**From:** Simon Davis  
**Sent:** 01 August 2022 18:30  
**To:** pope.stevens [REDACTED]  
**Subject:** AW/104/22/PL 8 Gossamer Lane, Aldwick

Drawing
Location, Site, Floor Plans

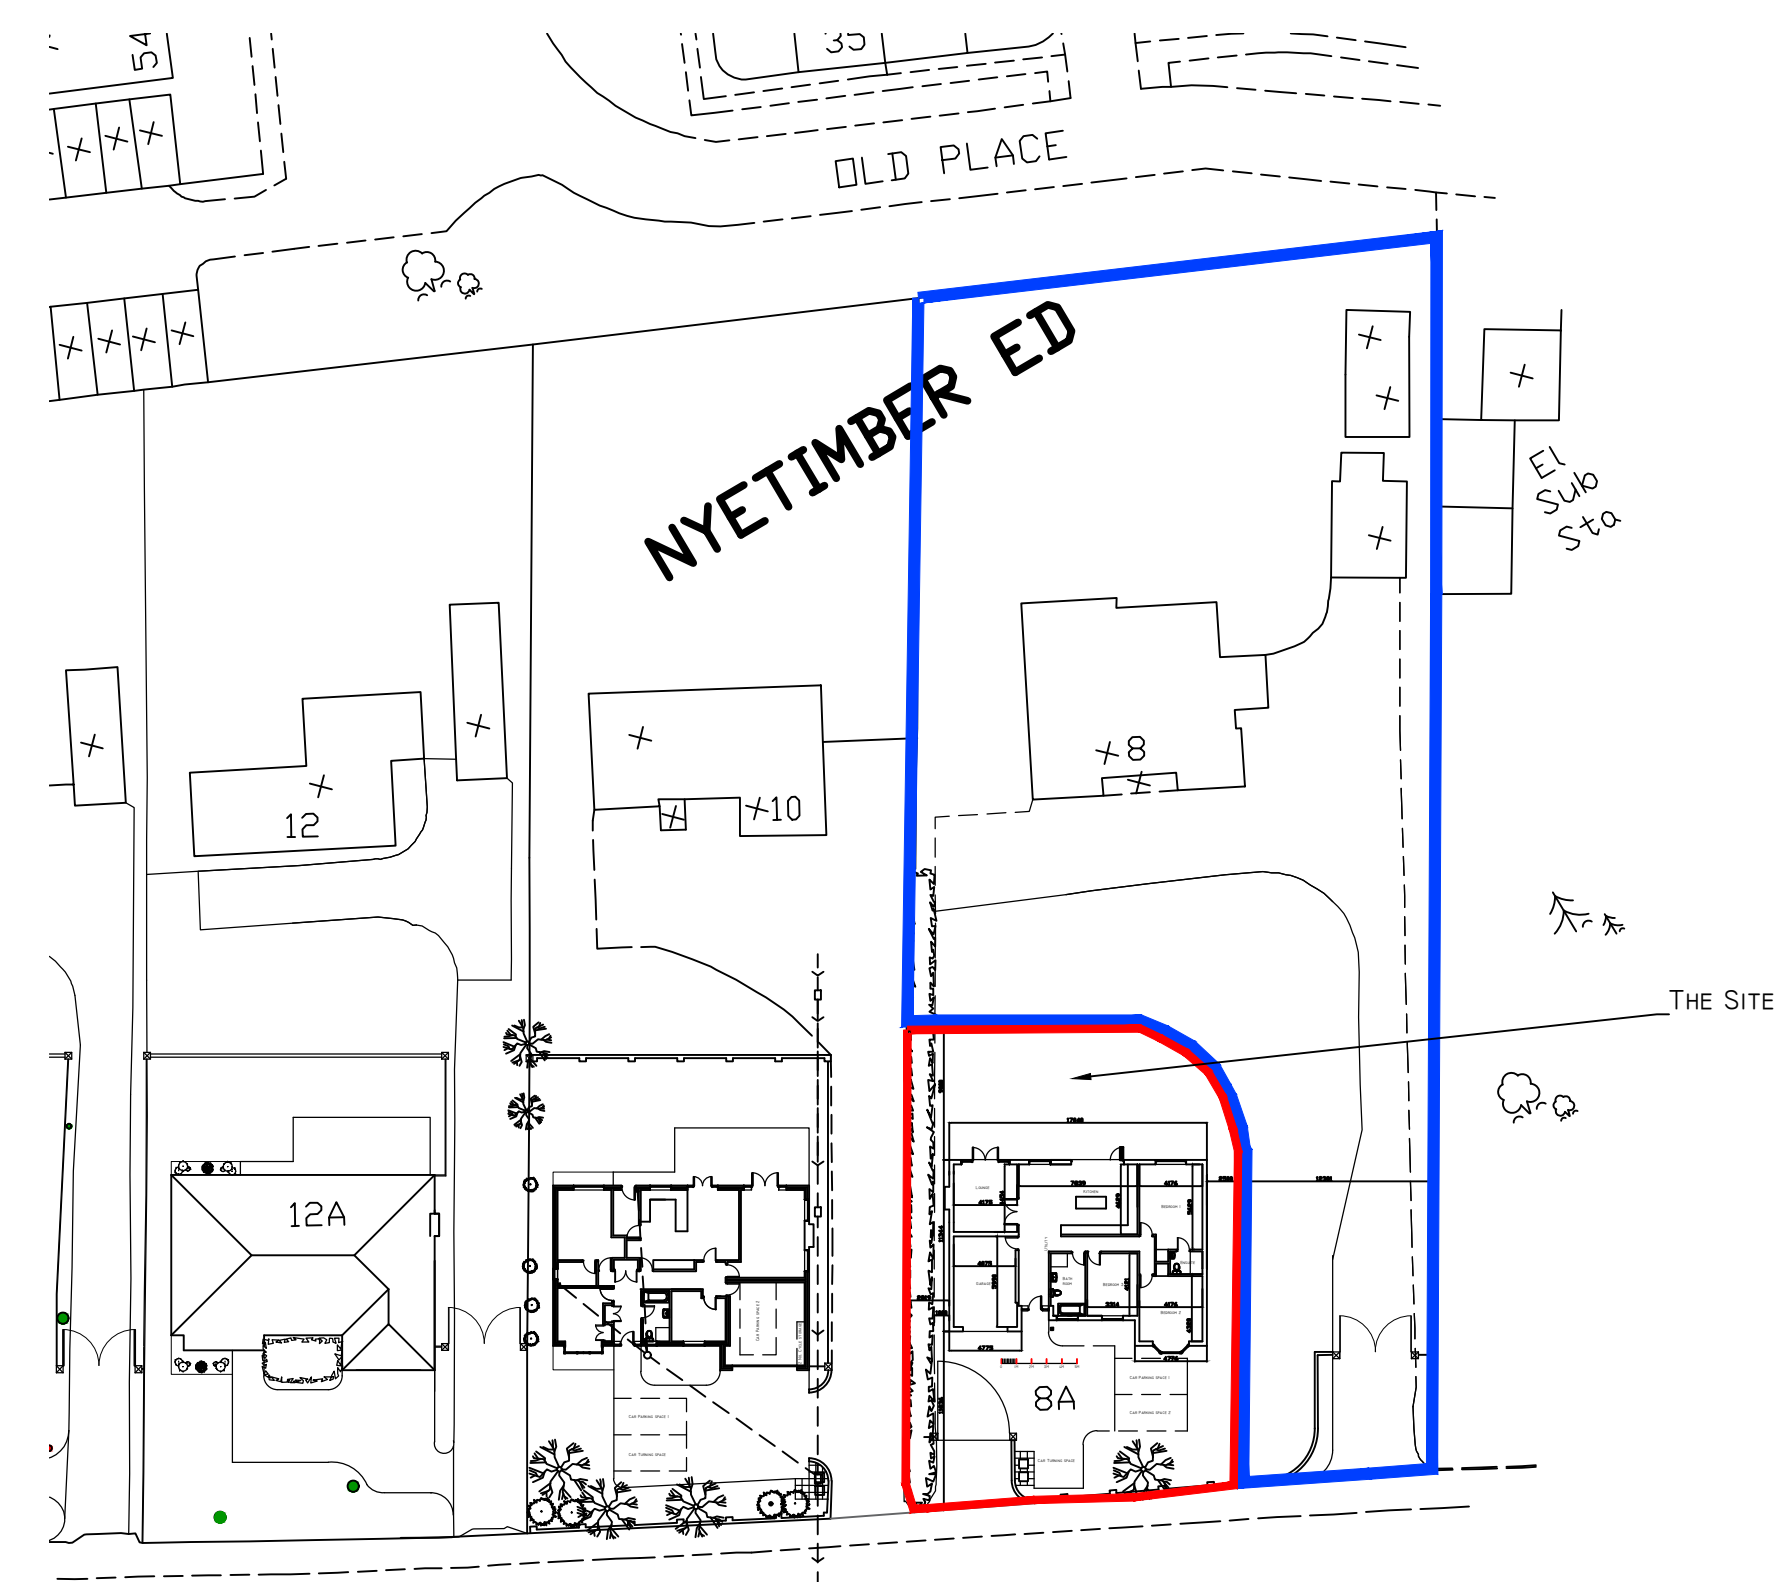
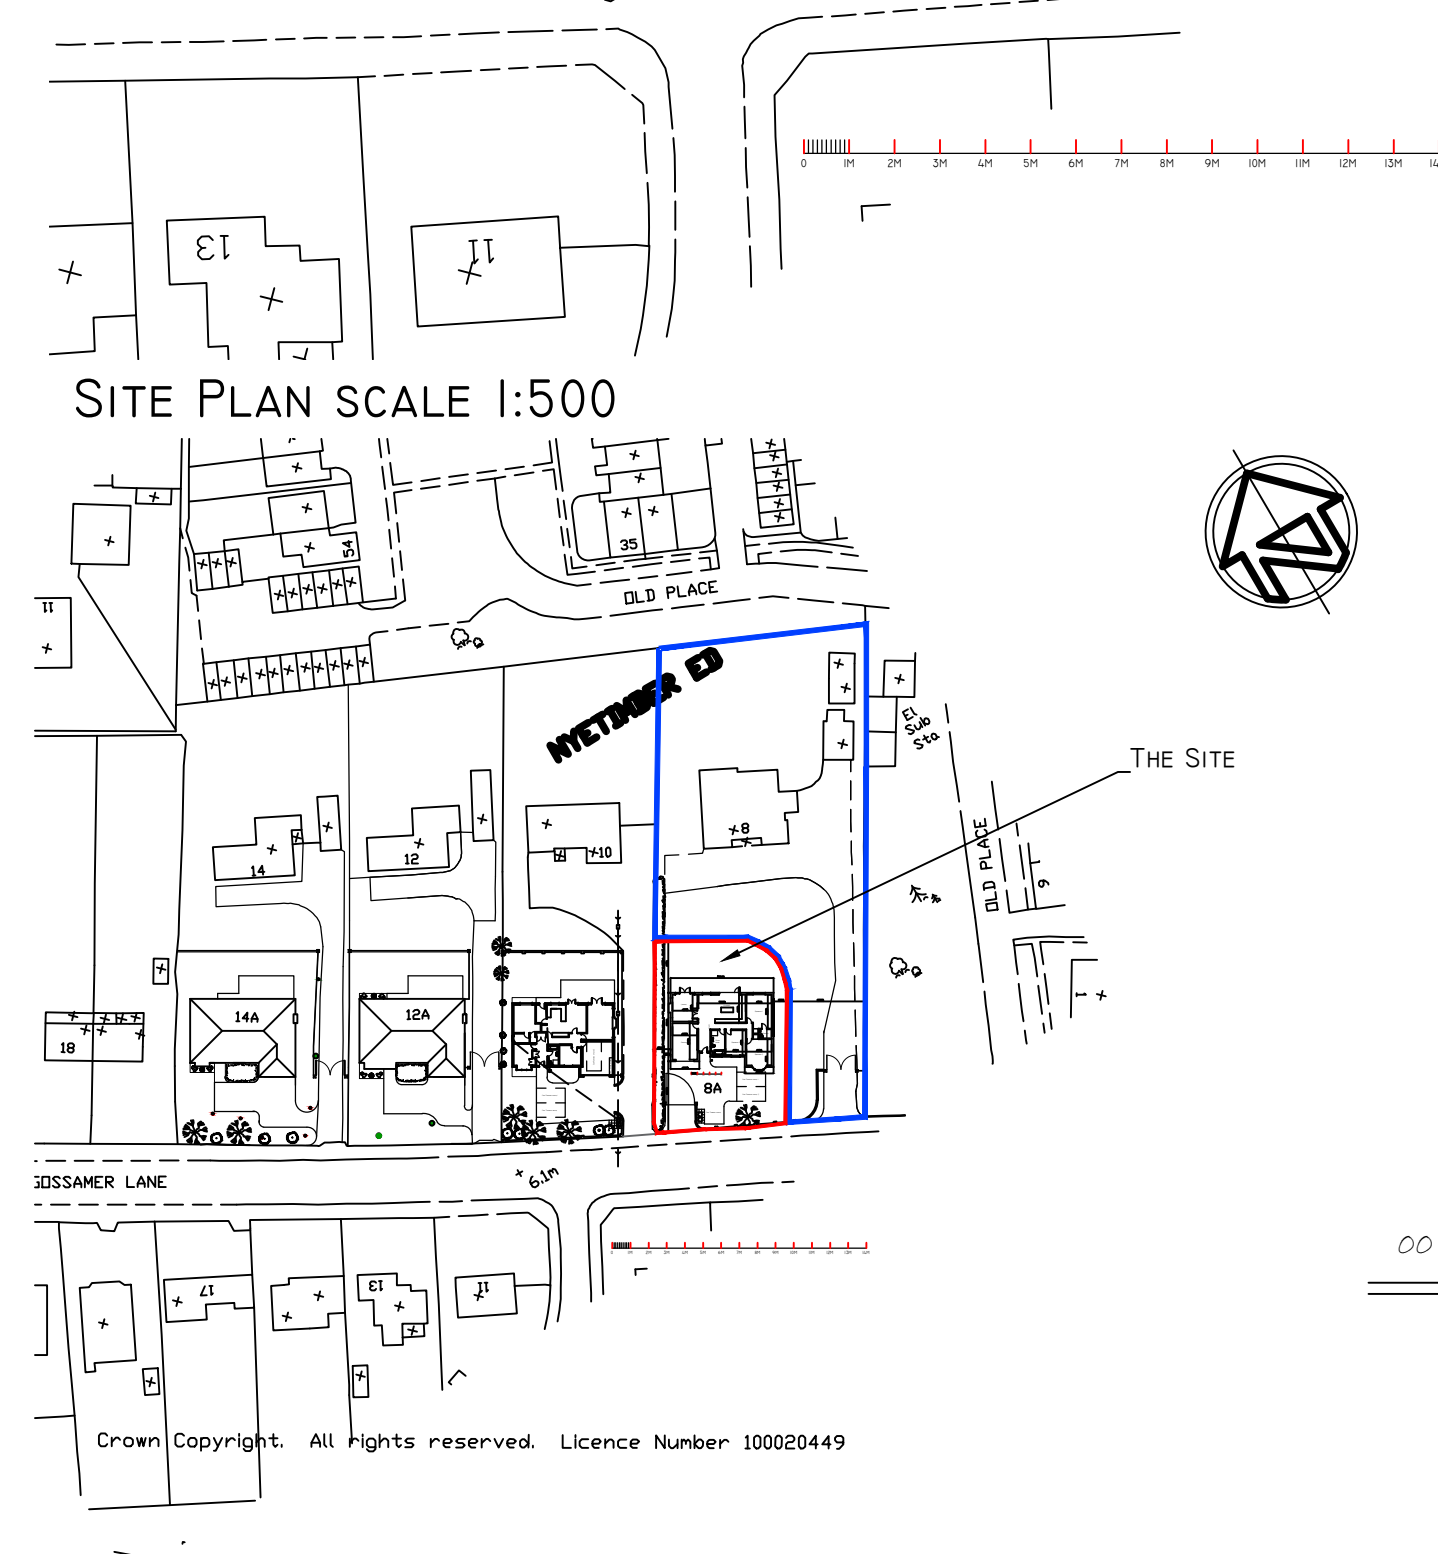
Our Conservation Officer has stated the following: *"It would appear that the existing (right hand) gate pier to the eastern access point, matches one found within the (Grade II Listed) Old Place development walling. It is recommended that this be retained in position as part of the alterations to the access points. Likewise, the remainder of the existing walling, whilst clearly modern, makes a positive contribution to the street-scene, and every attempt should be made for any alterations and new work to match the existing."*

I note that the gate pier falls within the blue not the red edge but can you confirm that no changes are proposed to the existing eastern access so that the pier can remain as is. I believe this to be the case but just need confirmation.
